From: Gareth Rollings
Sent: 09 September 2009 15:46
To: Planning.Responses
Subject: RE: Planning Consultation on: LU/247/09/

APPLICATION NO: LU/247/09/

Description of Works: Removal of existing benches and shelters on seafront promenade. Replacement with single bench structure from east Beach cafe to rear of concessions adjacent to Harbour Park (sited along southern boundary with existing dwarf wall).
 Erection of two new public shelter structures

Bench, Movement around
Lampposts and Bins

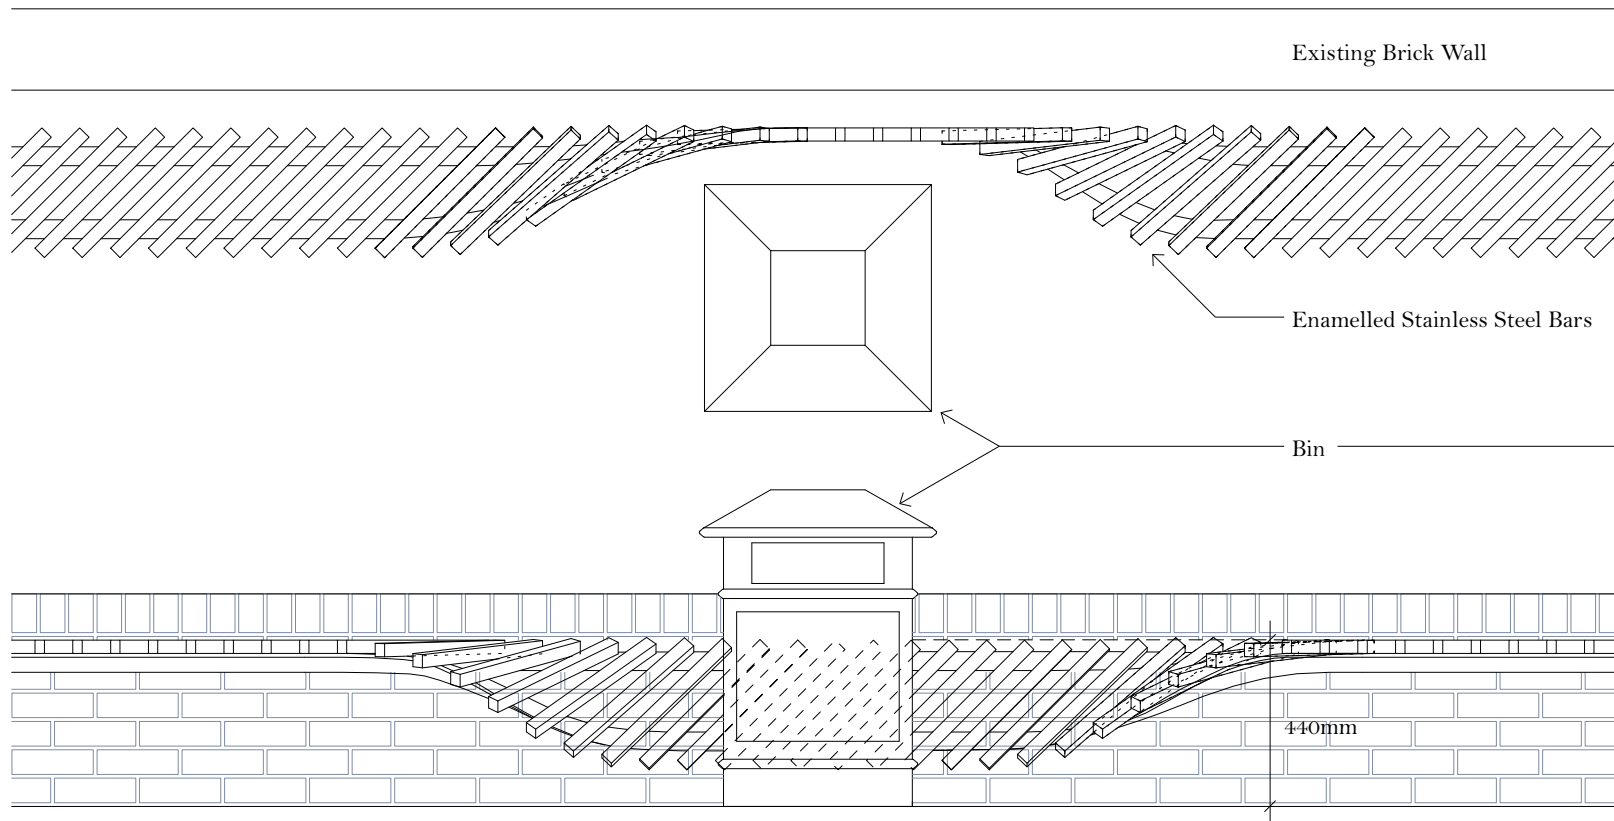
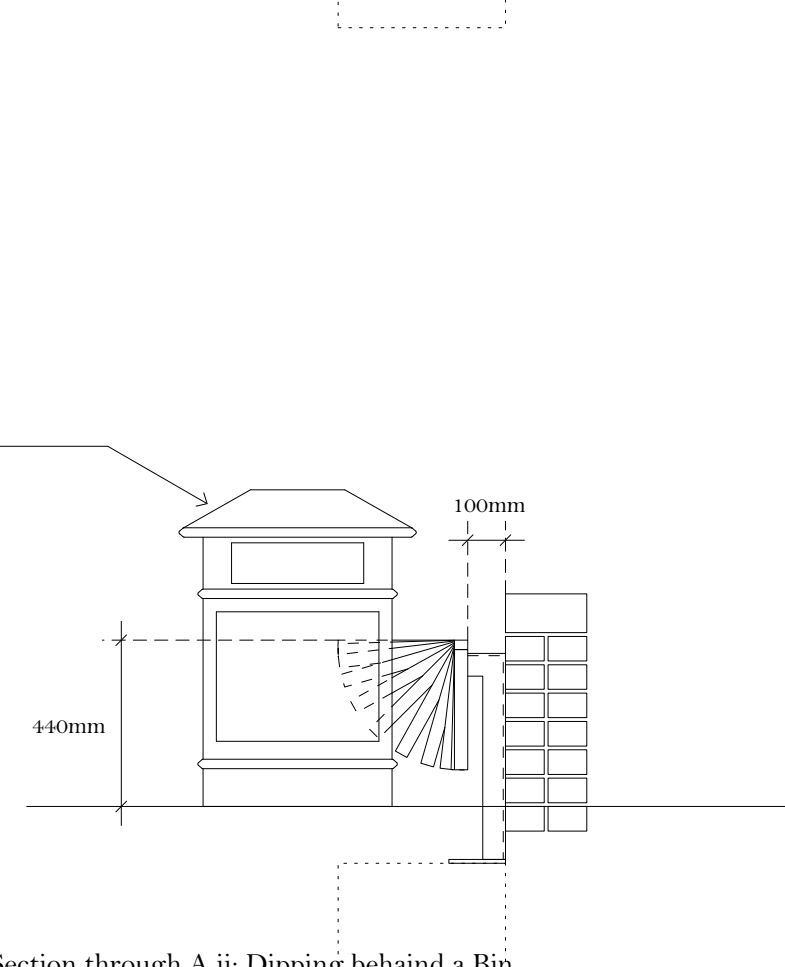
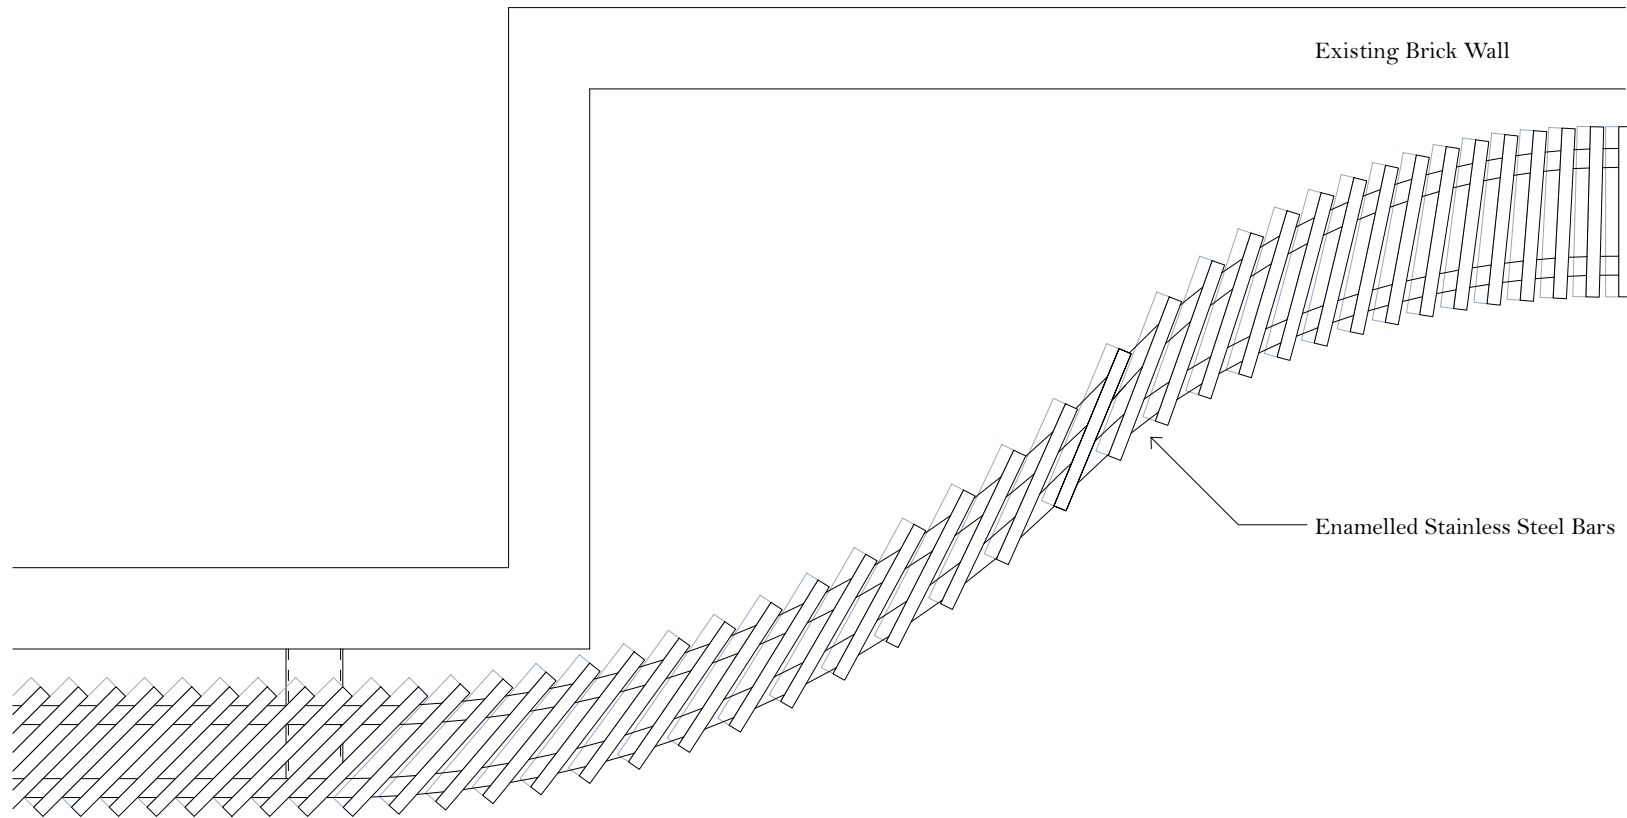
The design shows the bench running behind the bins which is fine as a concern was that the bins may have had to of been moved. In terms of Cleansing I note that the bench is accessible the only issue I have is that currently the area is cleaned by a mechanical sweeper. With the bench in place this will not be possible and will have to be hand swept, Verdant have to have the area clean by 8am as part of the contract, which without use of the sweeper may not be possible on a very busy day.
